20160966.2/2909A/R2/TT

12/10/2016

**UNSW Biological Sciences – Section 96 Amendment of Plans to SSD 6674 -
Acoustic Advice**

Acoustic Logic has been engaged to provide comment on acoustic impacts associated with proposed changes to the UNSW Biological Sciences Development (approved in SSD 6674).

1 EAST ELEVATION - FROM BOTANY STREET
SCALE 1 : 200

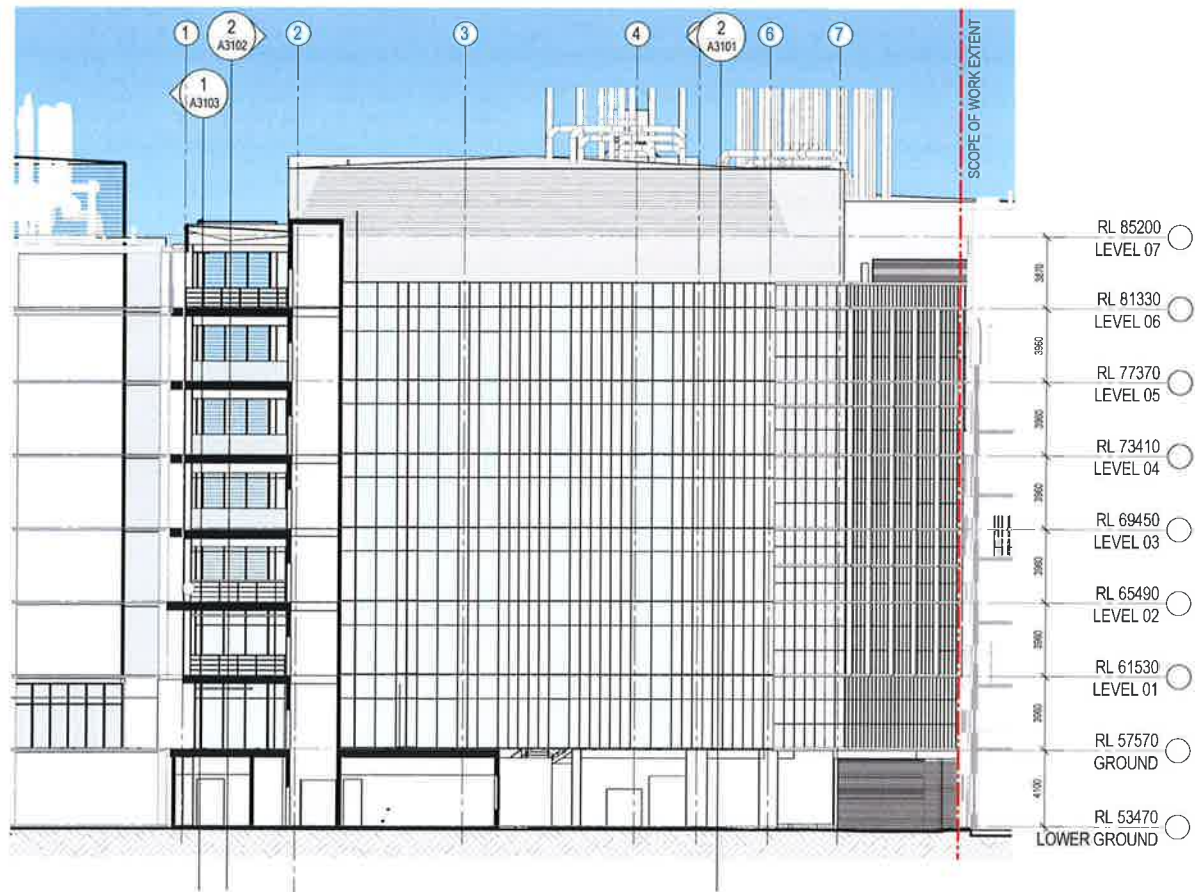
- Most critical is the acoustic design of a diesel generator located towards the eastern façade of building D26 (facing the Botany Street residences). This generator is to be housed within a proprietary sound enclosure (including acoustically treated air intakes/discharges and exhaust gas discharges). With this treatment, noise levels complying with those in table 1 can be achieved.

- Other significant plant items are located away from the eastern façade (the nearest façade to the Botany Street residences). Acoustic design of remaining plant items is to be conducted such that cumulative noise emission from all plant items will comply with the permissible noise levels set out in table 1.
